Application for a Non-Material Amendment Following a Grant of Planning Permission

Partial demolition of workshops/offices (building 2) and conversion to facilitate a gym with alterations to fenestration. Demolition of storage area and partial conversion of existing stables with installation of mezzanine floor for light industrial/workshops and offices, with alteration to fenestration. Erection of two stable blocks. Relocation of site access and associated landscaping.

19/02061/FUL

2023-825-(BR)-2002 P02 – Unit 2 – Plans and Elevations

**DRAWING TITLE**  
UNIT 2 - PLANS AND ELEVATIONS

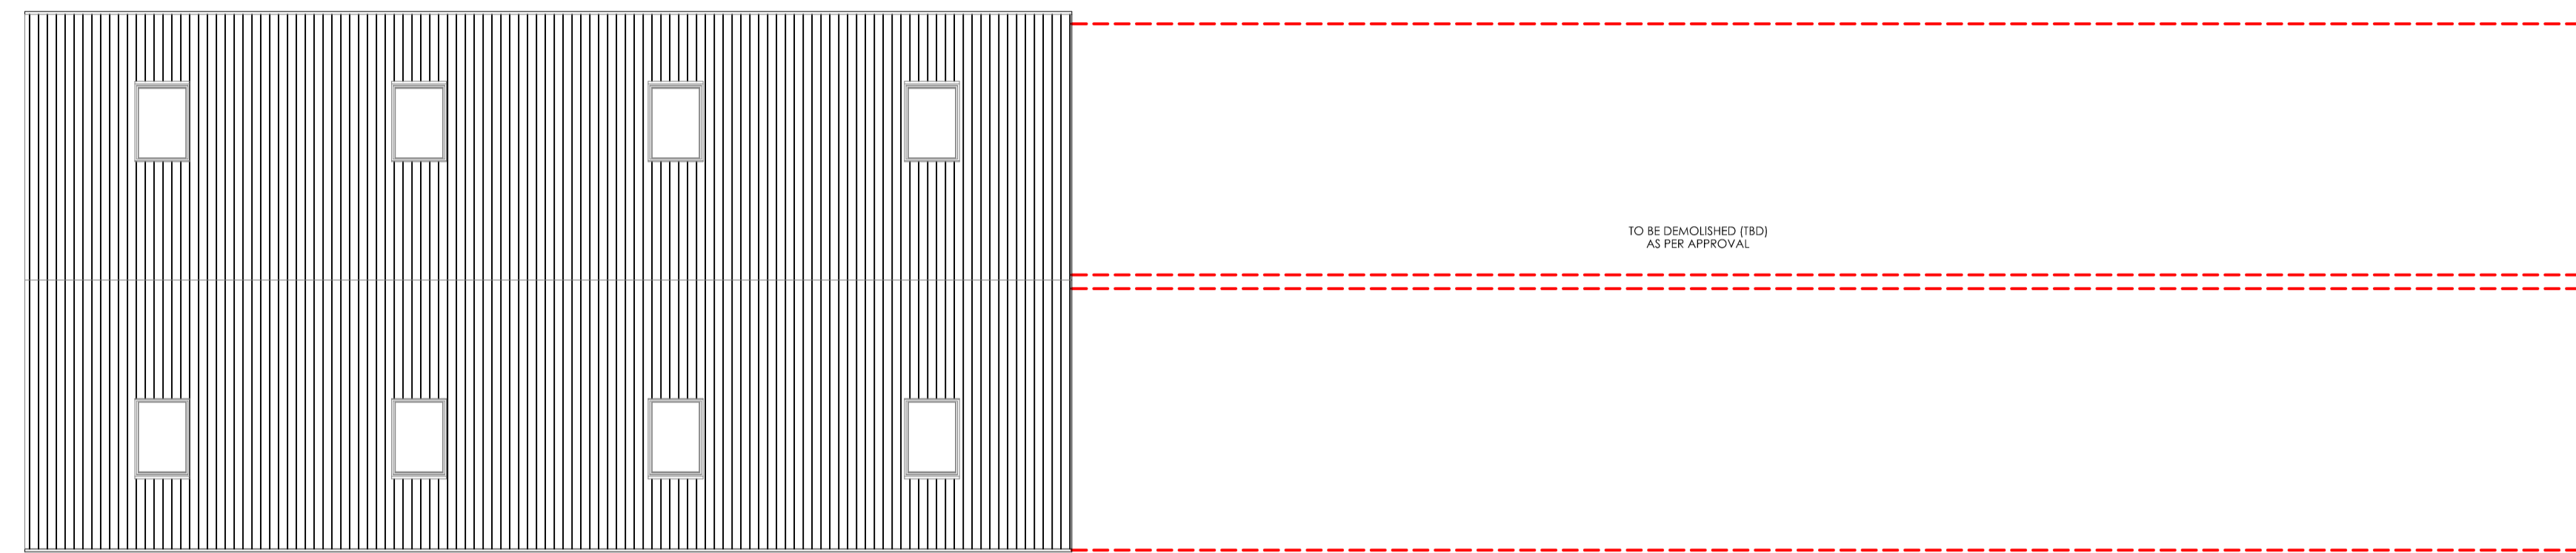
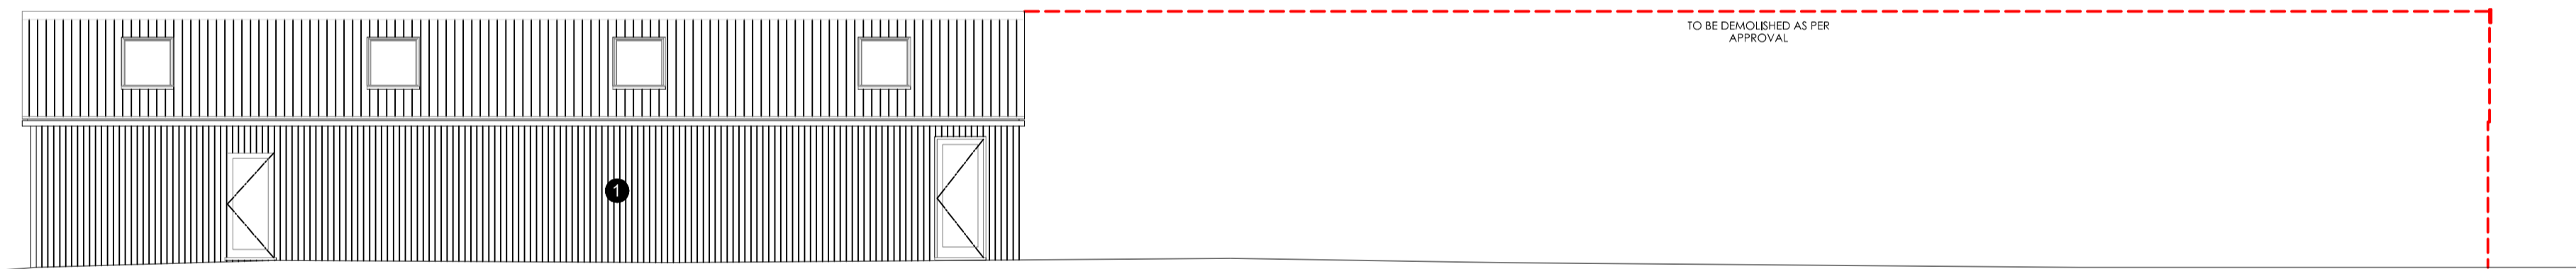
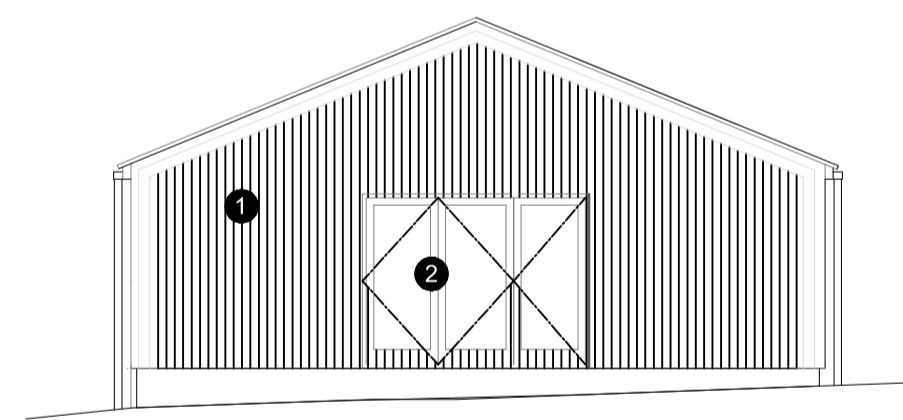
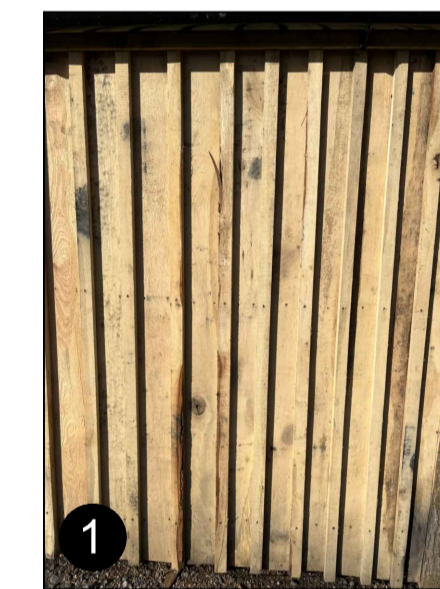
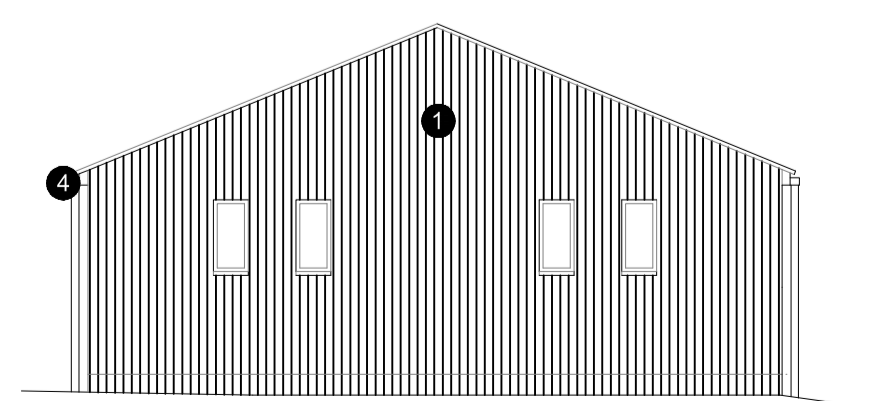
We propose to amend the approved plans for Unit 2's floor plan, roof plan and elevations. The proposed roof plan features the same number of rooflights as formerly approved. These are broadly in the same location and are of a similar size to the original approval. The proposed east elevation appears the same as the original approval. The proposed west and east elevations demonstrate reduced fenestration and more basic form than was previously supported. Similarly, the proposed north elevation seeks a reduced fenestration and a simpler design aesthetic. Internally, the proposed layout offers the same open area gym with ancillary areas to the east. The proposed layout includes a complimentary physiotherapy area when needed and an office for gym management.
